13 July 2018

Our Ref: 172989

RE: Development Application - Sydney Football Stadium Redevelopment, 40-44 Driver Avenue, Moore Park (SSD 9249)

**Figure 10: Existing Sydney Water network map in the vicinity of the site**

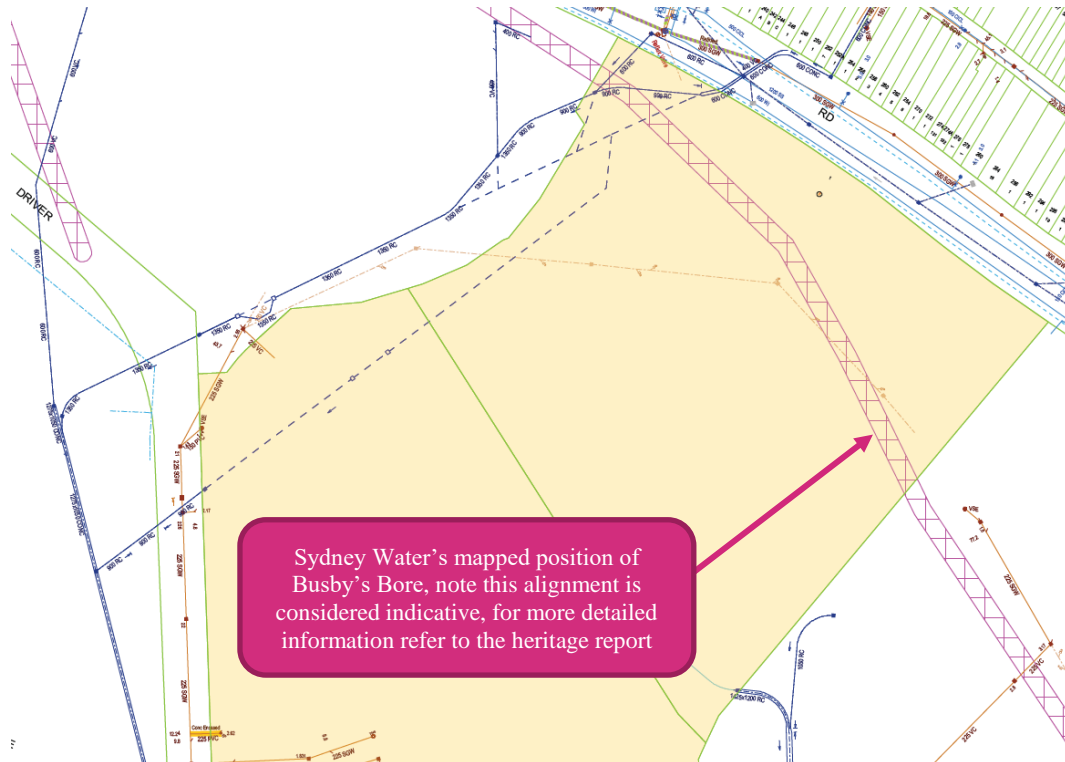
Sydney Water stormwater assets of greatest concern are the 900RC, 1350RC and 400VC part of the Moore Park- Sportsground Eastern Branch.

- No building or permanent structure is to be constructed over Sydney Water stormwater channels / pipes or within **1m** from the outside wall of the stormwater asset. Permanent structures include (but are not limited to) basement car park, hanging balcony, roof eaves, hanging stairs, stormwater pits, stormwater pipes, elevated driveway, basement access or similar structures. This clearance requirement would apply for unlimited depth and height.

- An elevated // cross-section drawings must be submitted to ensure that the proposed buildings and permanent structures are 1m away from the outside face of the stormwater channel and below the line of influence.

Sydney Water recommends that the applicant work closely with Sydney Water during the concept phase of this proposal. As are the current stands, the proposal does not meet Sydney Water's building over and adjacent to the stormwater assets requirements.
